**WEST SUSSEX COUNTY COUNCIL
STRATEGIC PLANNING CONSULTATION**

DATE: 29TH November 2013

SUBJECT: BR/249/13 - Change of Use of ground floor from Motor Vehicle Sales & Servicing/Repairs (Sui Generis) to A1 (Shops) Food Retail.

Nyetimber Mazda, 33, Chichester Road, Bognor Regis, West Sussex, PO21 2XH

Site Plan

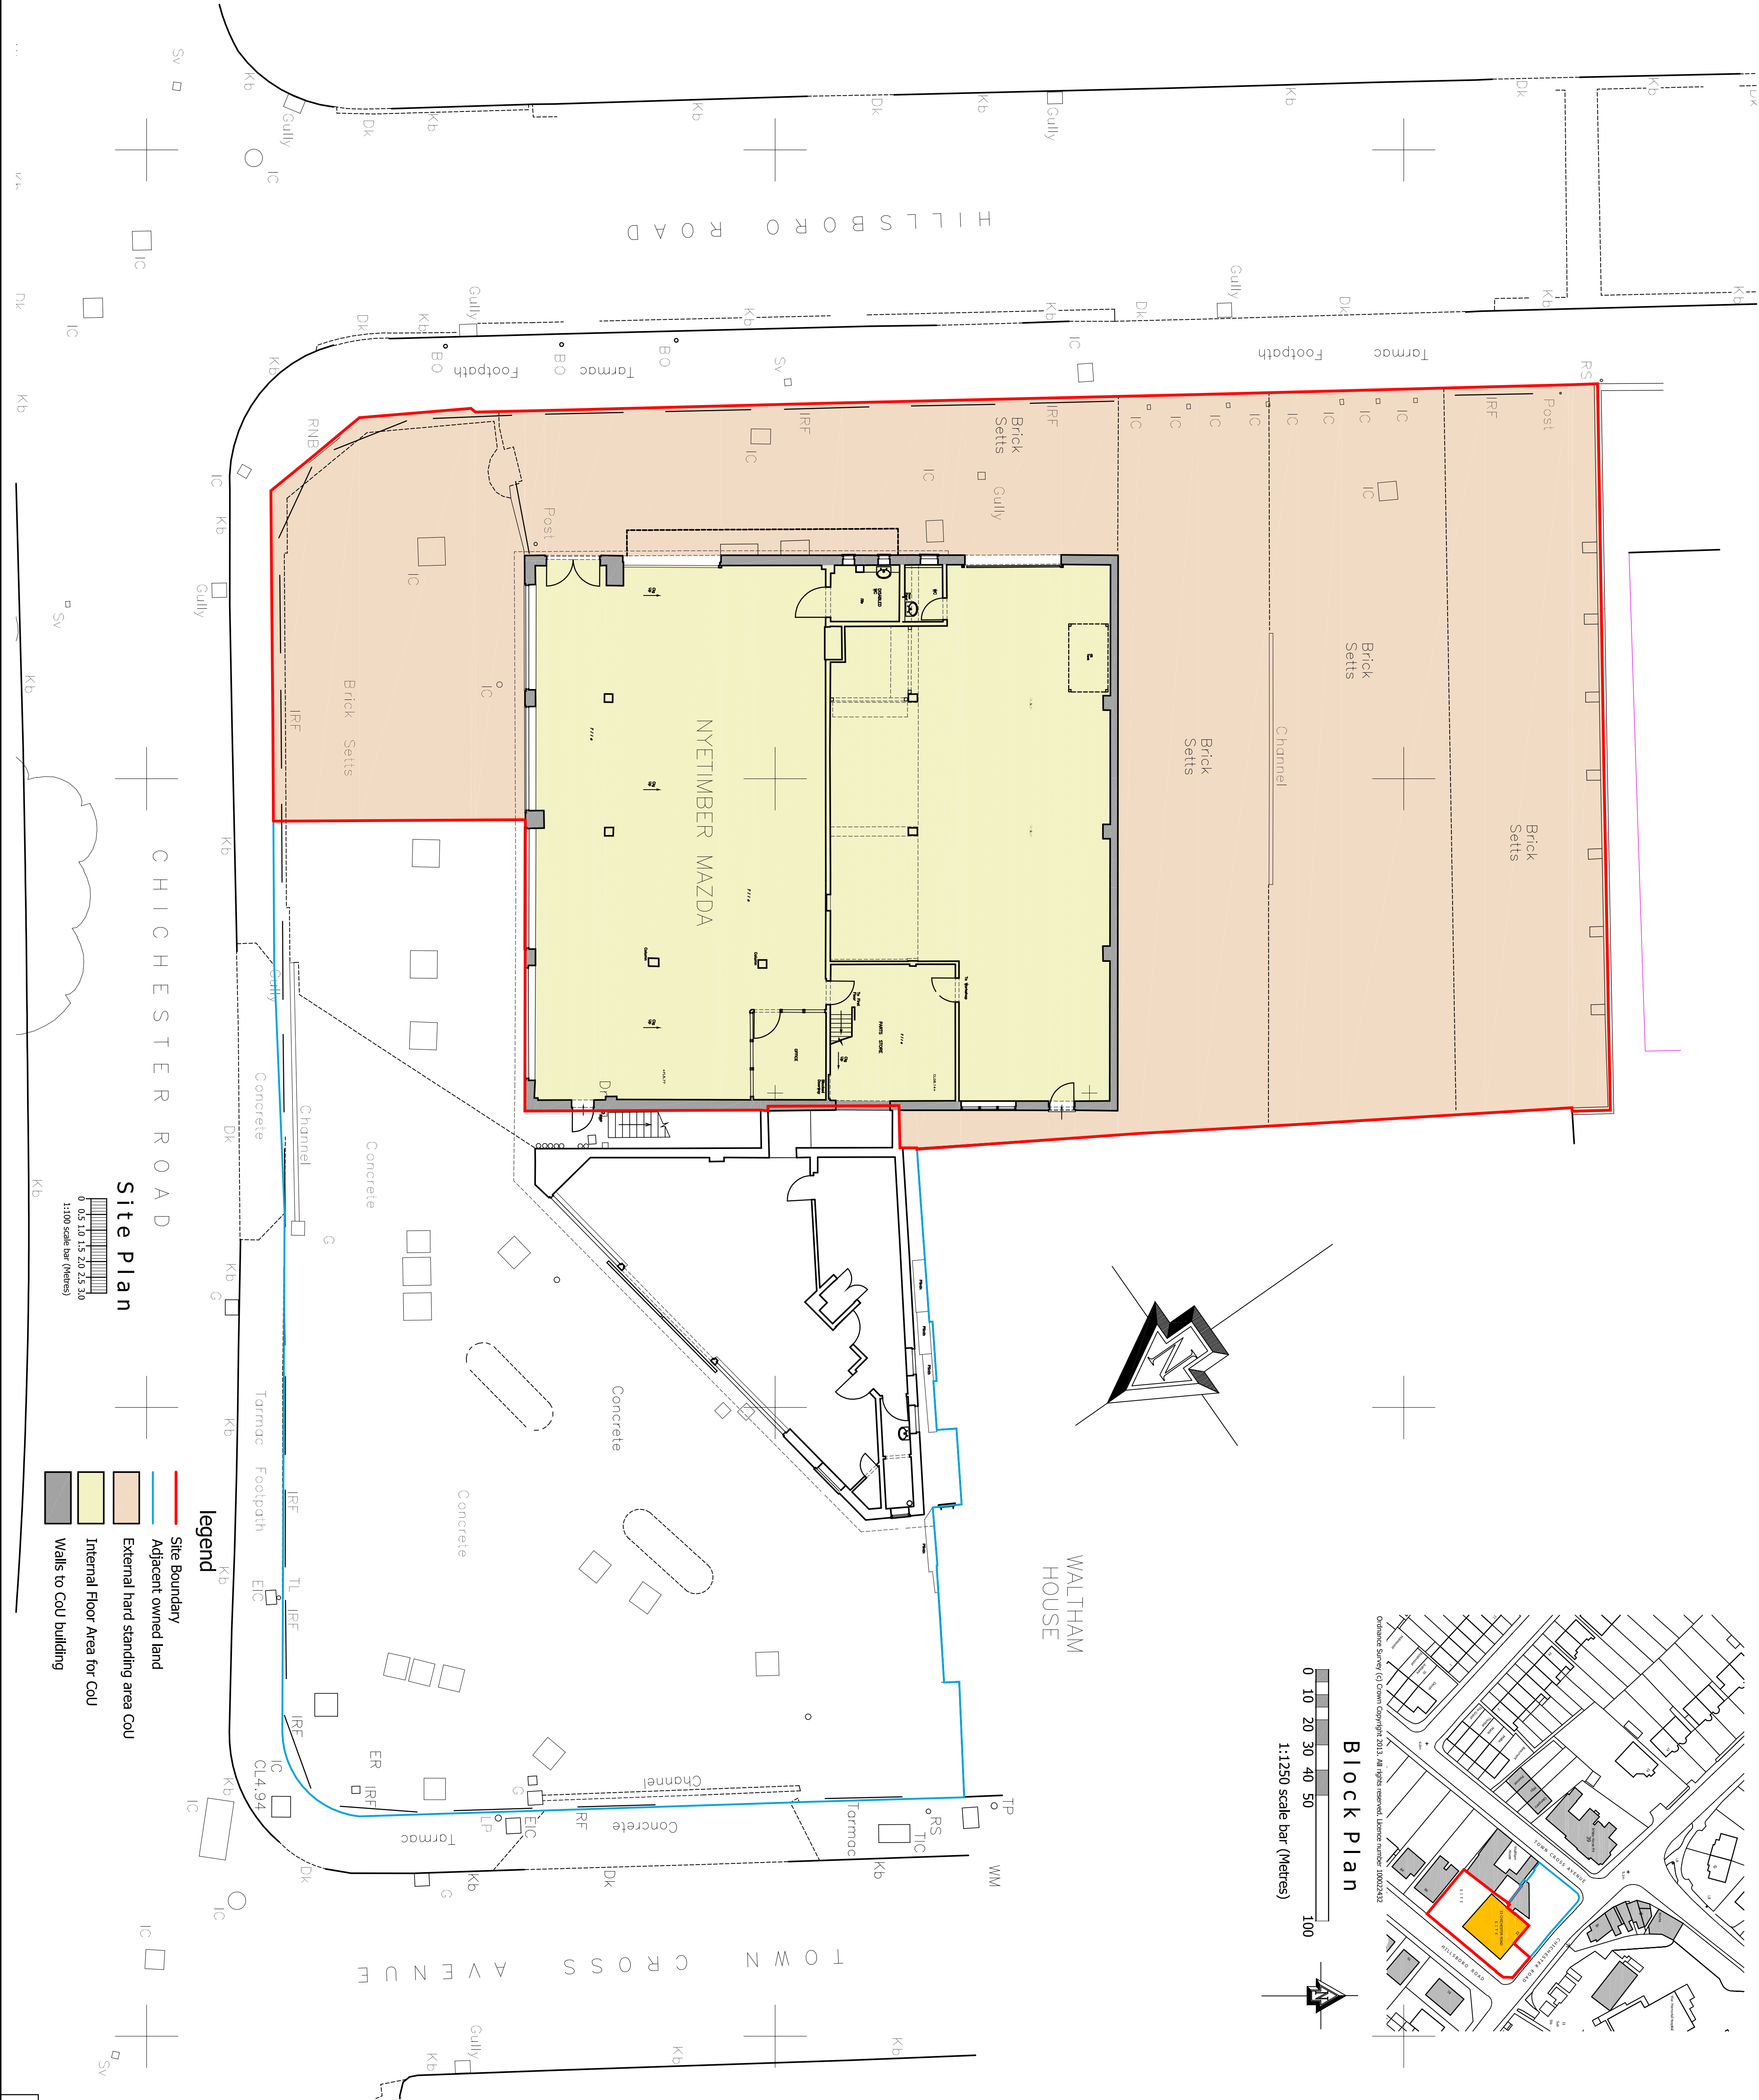
The proposals include the re-use of the 18 space car park, to provide 15 spaces, with the remaining three spaces kept back and used for bin storage. This will provide parking for customers and staff. It is anticipated that there will be 20 employees at the store, with approximately 5-8 staff working at any one time. WSCC car parking standards recommend that the expected car parking demand for A1 use is 1 space per 14sqm, and the development should provide 22 spaces, 5% of these should be designated disabled parking. As the car park has been in use as part of the existing establishment WSCC are satisfied that the parking spaces set out meet current standards. However; as the proposed number of spaces is below our recommended standard, WSCC have undertaken a review of a selection of car parking accumulation surveys, submitted by the applicant, to ensure the 15 spaces proposed meet the expected demand.

A site visit was undertaken on the 19th of November 2013. The existing access into the car park forms a crossover onto Hillsboro Road, and visibility here is adequate for its proposed use. It was noted the kerb running from the car park access to Chichester Road junction, would benefit from some repair work, as the kerb line is falling away from the footway. Clearly this has been used by vehicles mounting the kerb in relation to the existing motor repair use. Considering this change of use will attract a much higher level of pedestrian footfall it is noted that a pedestrian crossing is located 50m away and allows the safe crossing of the busy A259 for people wishing to use the store from the North. A review of the existing pedestrian crossing points on the corner of Hillsboro Road show these to be worn and it is recommended these are upgraded within the associated development works.

Cycle storage is included within the application and should be in line with WSCC car parking standards. These recommend at least 1 space per 100sqm for staff and customers. Therefore 6 spaces should be provided. The store is within a sustainable location with easy access by car via the A259 'commuter route' in both easterly and westerly directions. Its is also within walking distance of the main bus routes serving the town and beyond and is less than 800m from Bognor Regis mainline railway station meeting the IHT guidelines for providing journeys on foot.

Car parking space (details required)

No part of the development shall be first occupied until the car parking spaces have been constructed in accordance with plans and details submitted to and approved in writing by the Local Planning Authority. These spaces shall thereafter be retained at all times for their designated use.

Cycle parking (details required)

No part of the development shall be first occupied until covered and secure cycle parking spaces have been provided in accordance with plans and details submitted to and approved by the Local Planning Authority.
